Ashfield Council

20 May 2013

Stage 1 Project Application 2-32 Smith St Summer Hill

At its meeting on 14 May 2013, Council resolved as follows:

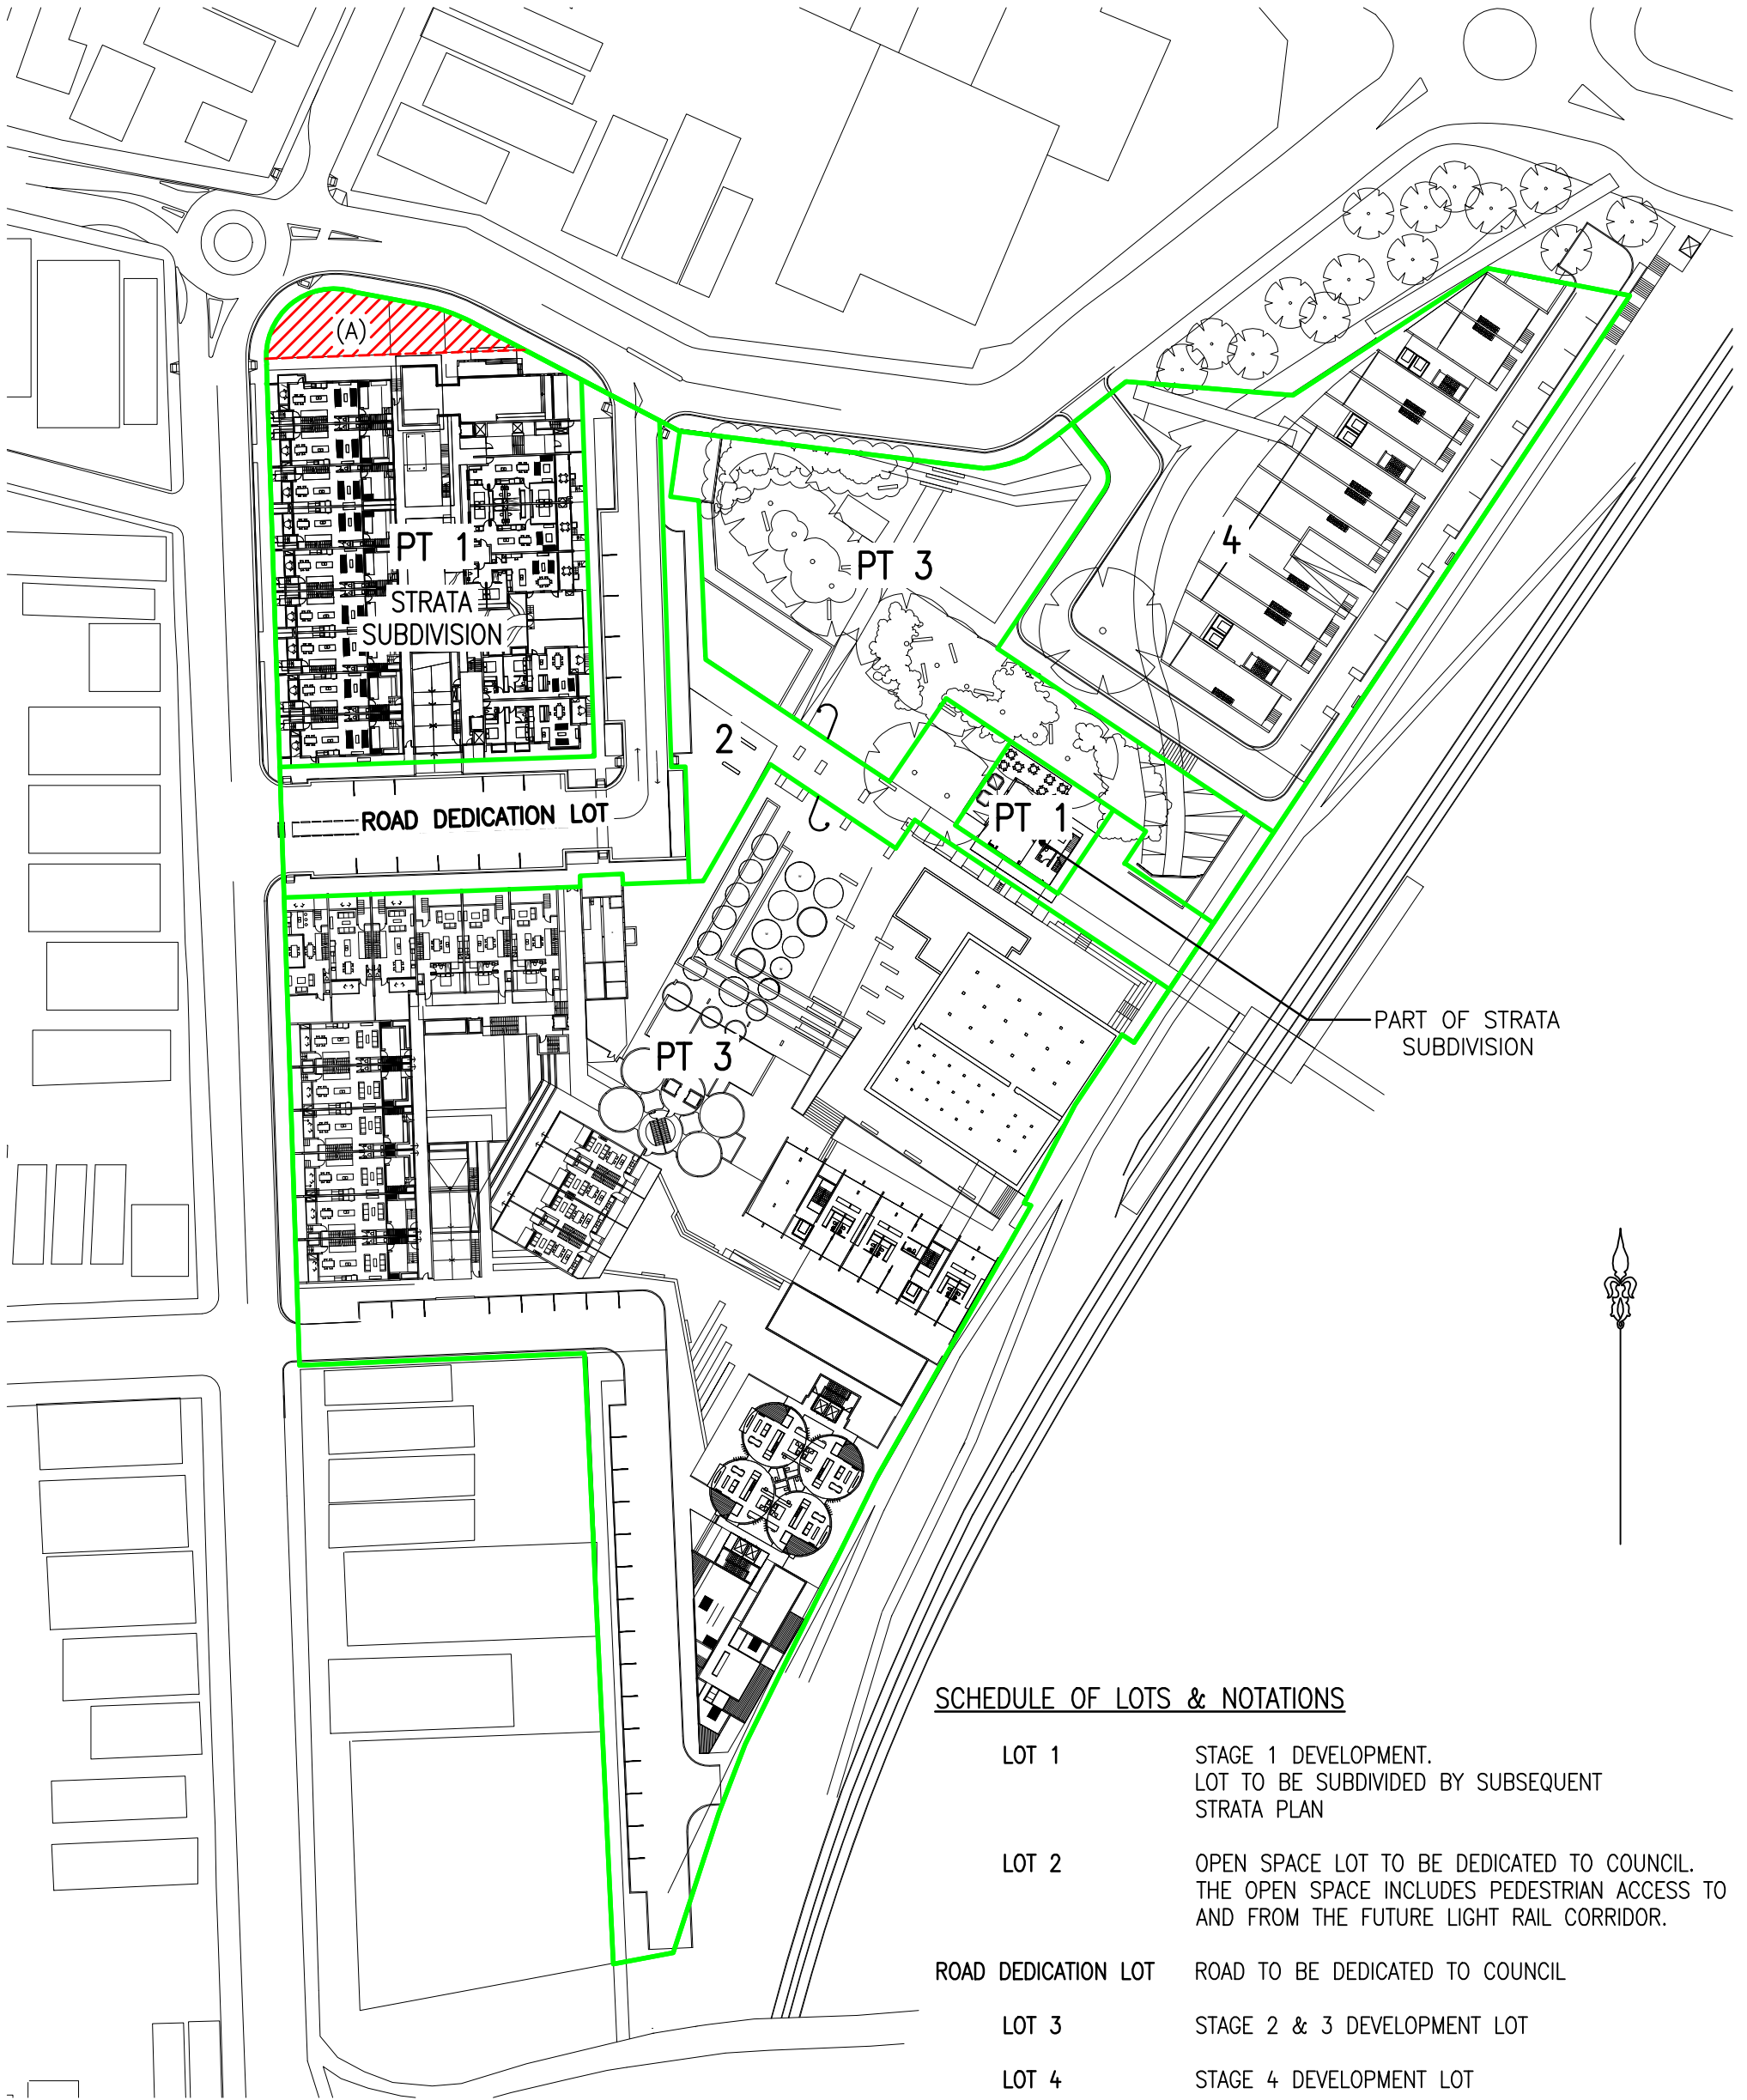
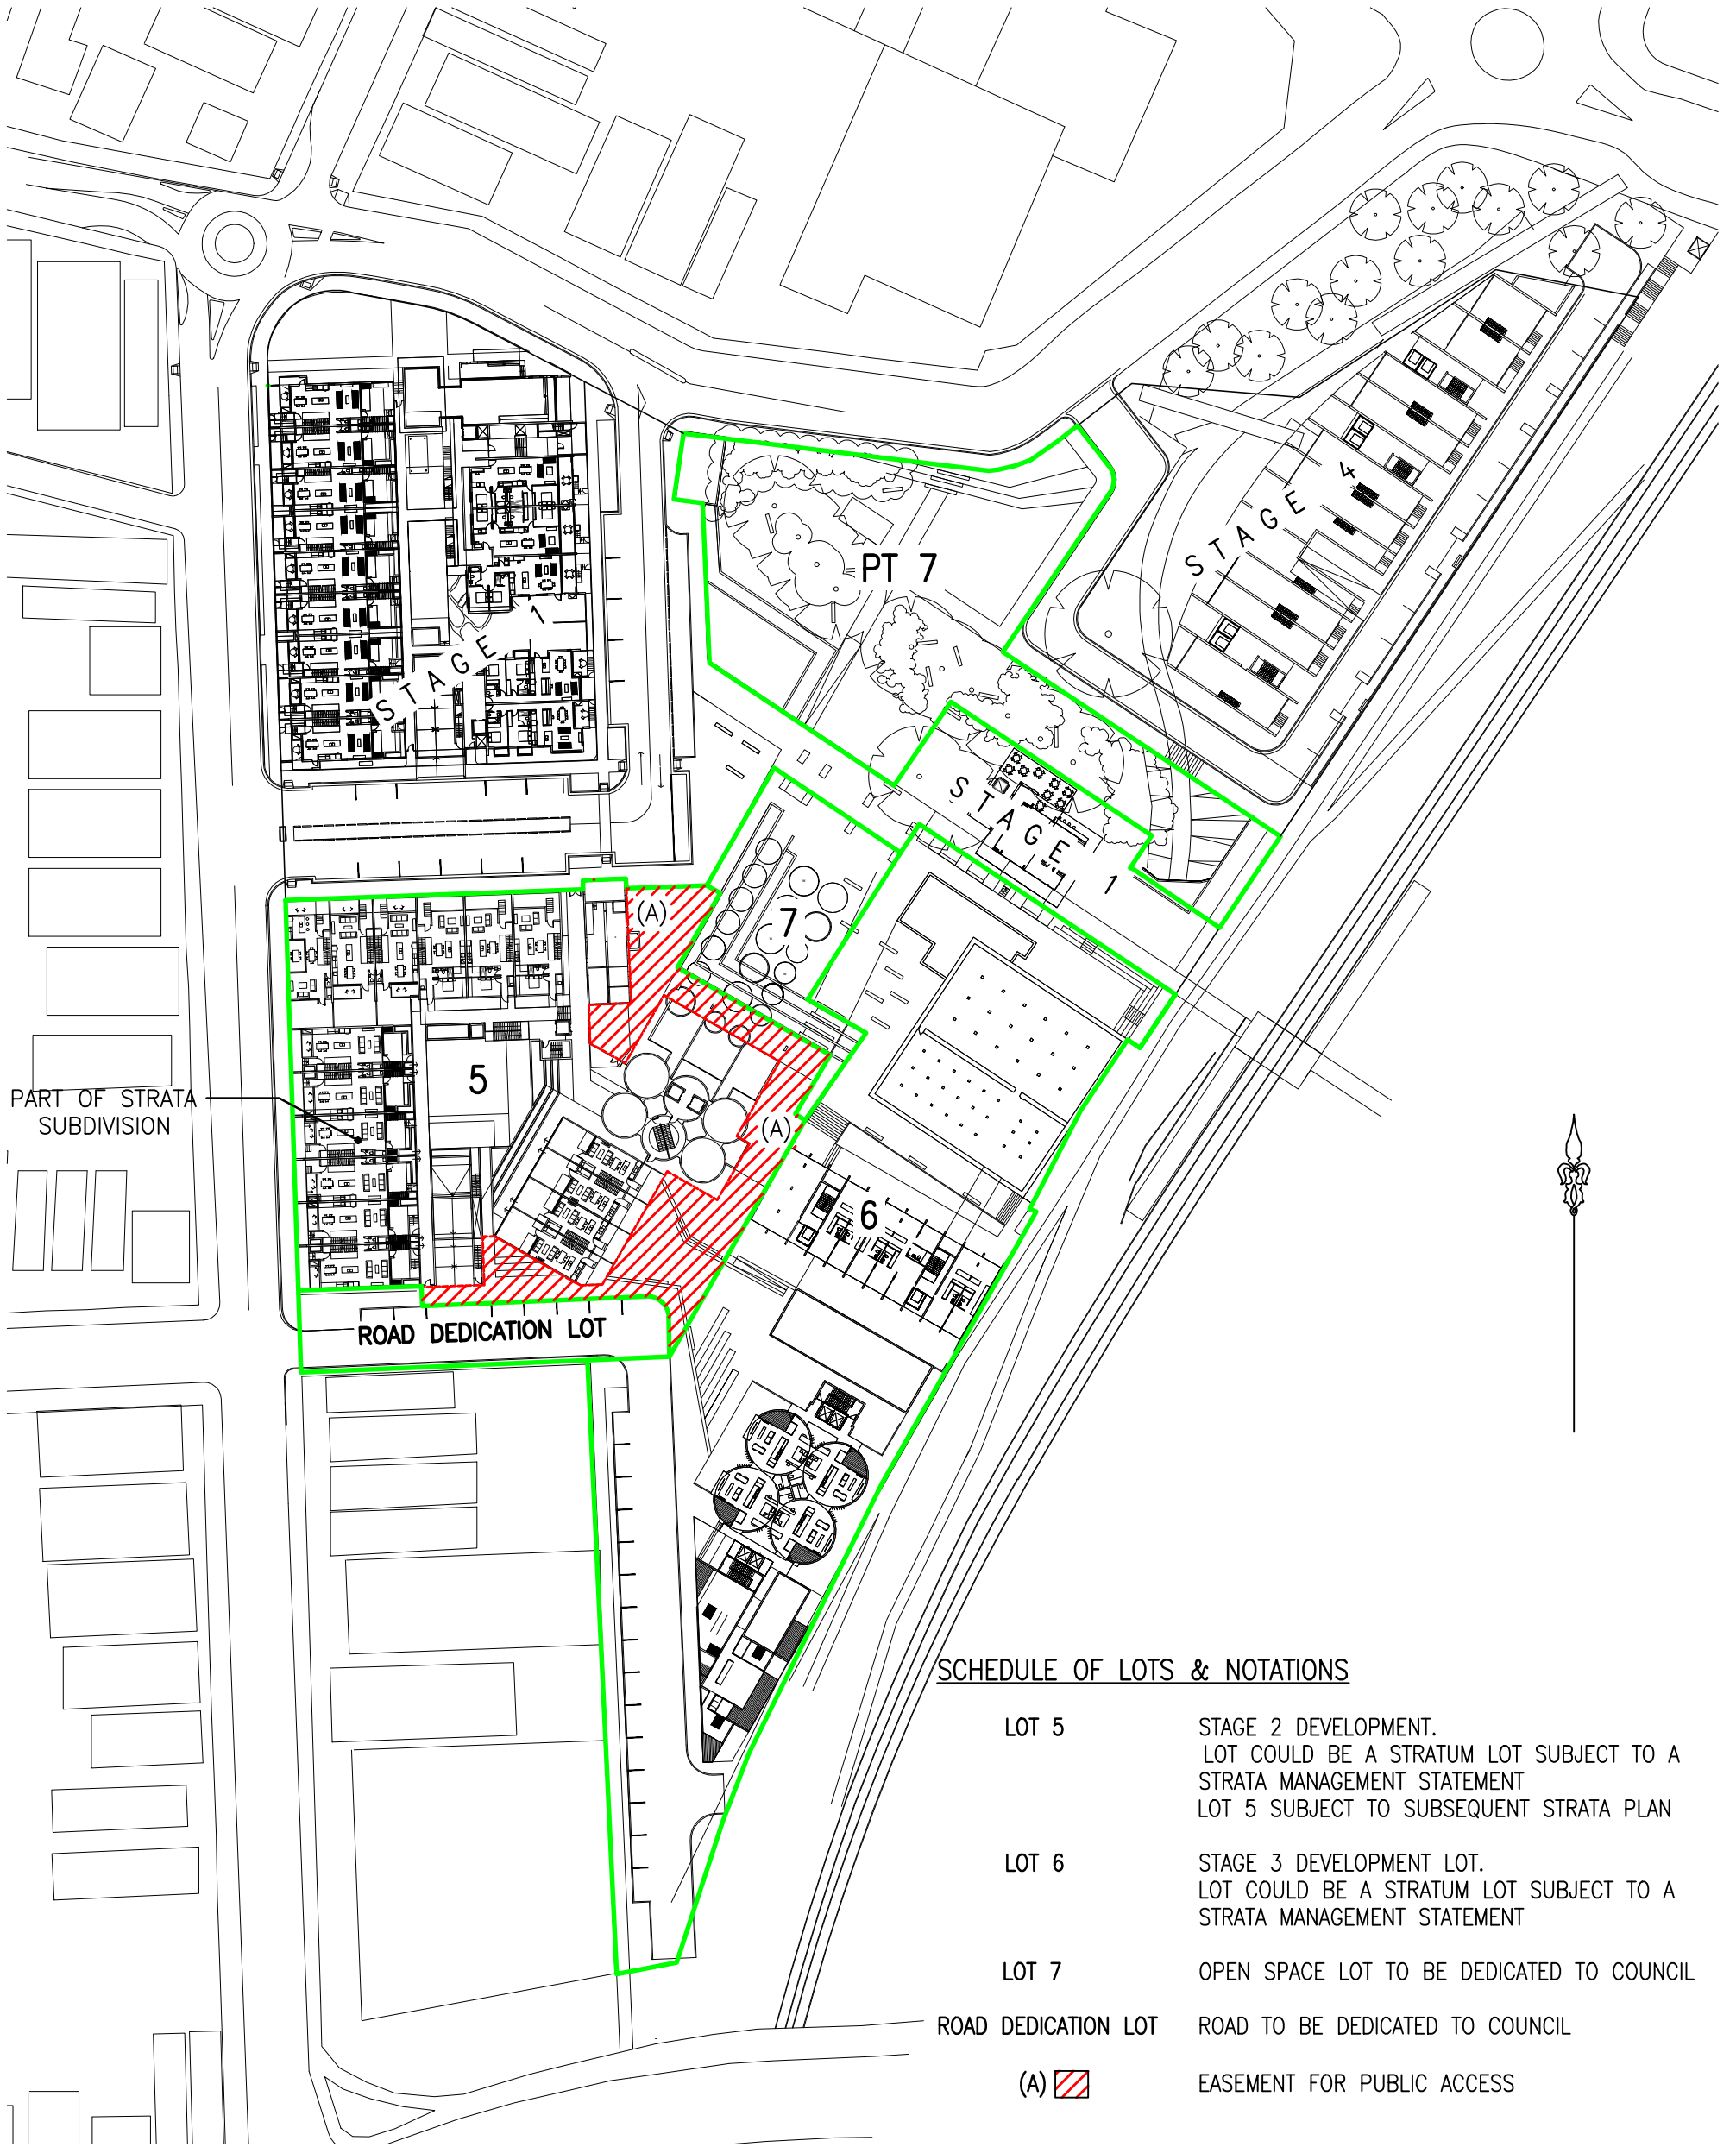
- 1) That pursuant to the 'Concept Approval' conditions no 23, 24, 25 and 26 requirements are placed on the land title of new allotments to ensure that the following occurs:
- (i) Publicly accessible open space is provided for the relevant allotments, including the 'Portion 4' allotment which on the approved Concept Plan is described as open space.
- (ii) That the pedestrian public access way to the proposed Light Rail station from the internal street to the boundary with the Railways land and Light Rail station, which is proposed to be dedicated to Council and shown on the subdivision plans, have a minimum width of 8m, as shown on the approved Concept Plan drawings.
